EPC STORMWATER REVIEW COMMENTS
IN ORANGE BOXES WITH BLACK TEXT

CITY LINK TRUCKING

Grading & Erosion Control Plans

PCD File # PPR2339

SITE GRADING AND EROSION CONTROL PLAN

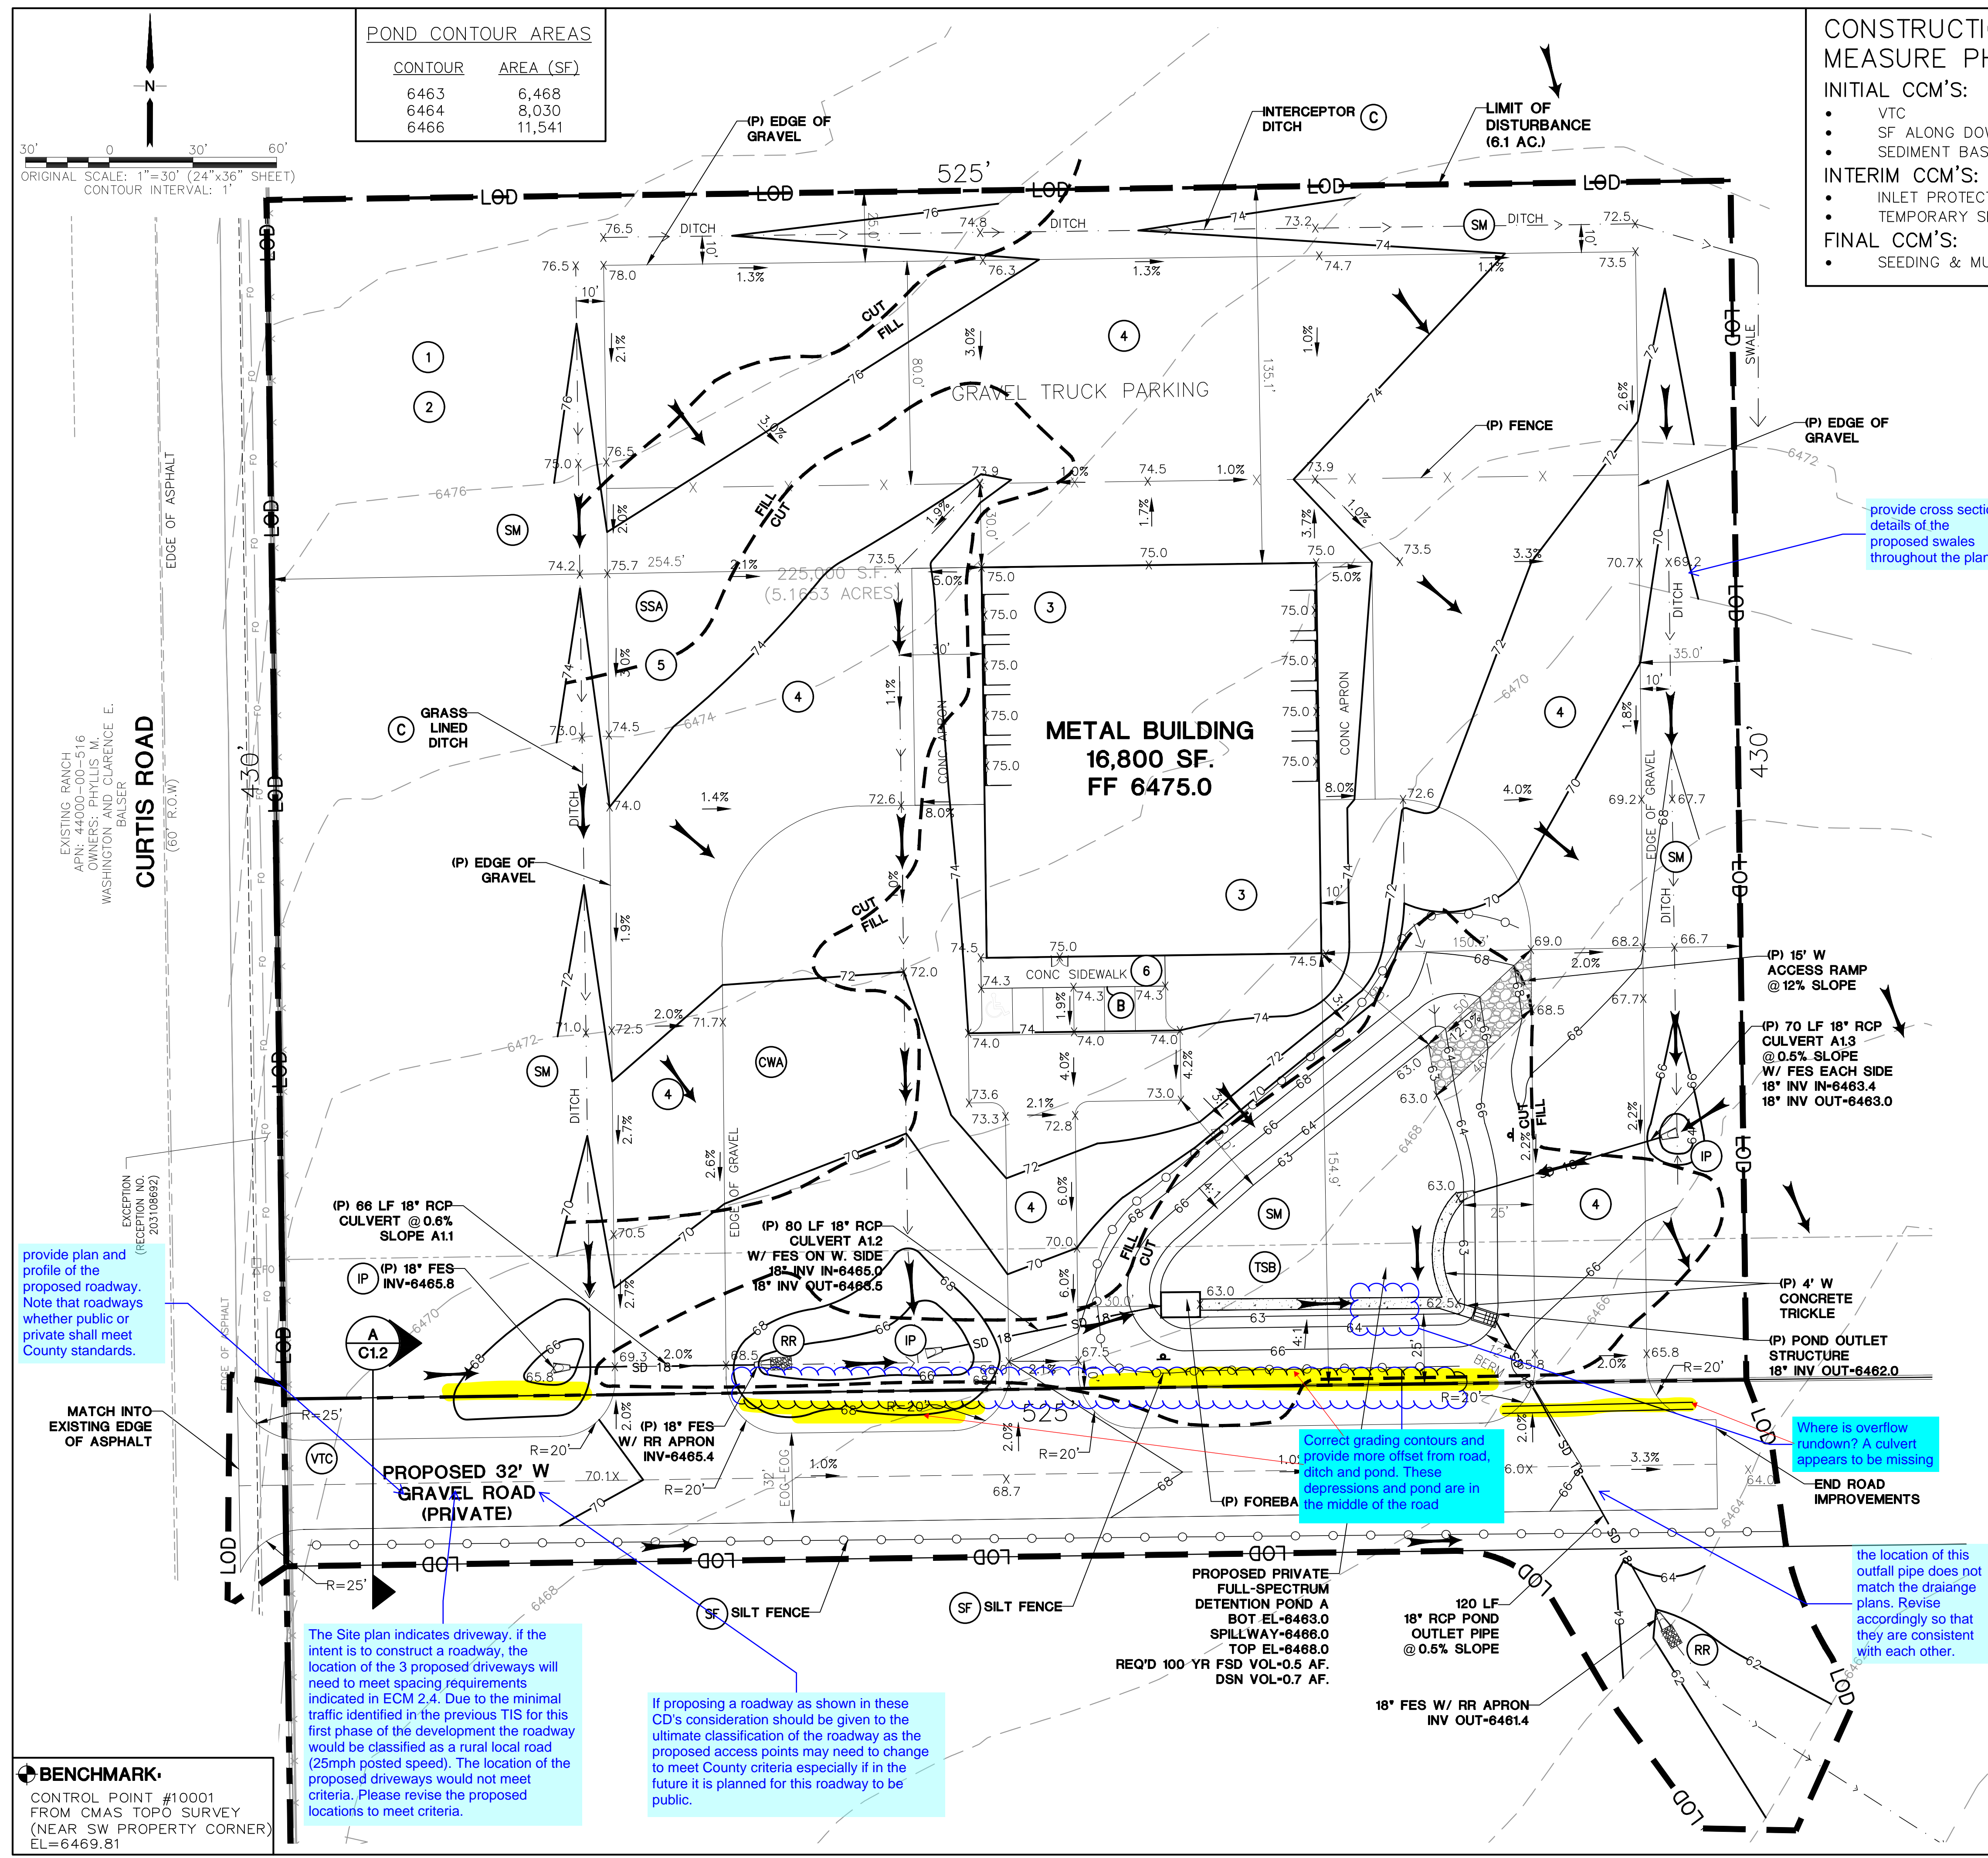
Call out ditch and denote culvert as needed. Show contour grading and tie in with existing road.

Depict 50ft long paved apron

Where is this? Is C&G being added? Call out on plans

GEC Checklist Items n and o - Identify and protect areas of work outside of the construction boundary w existing fencing, construction fencing etc. Clearly show and call out off-site grading.
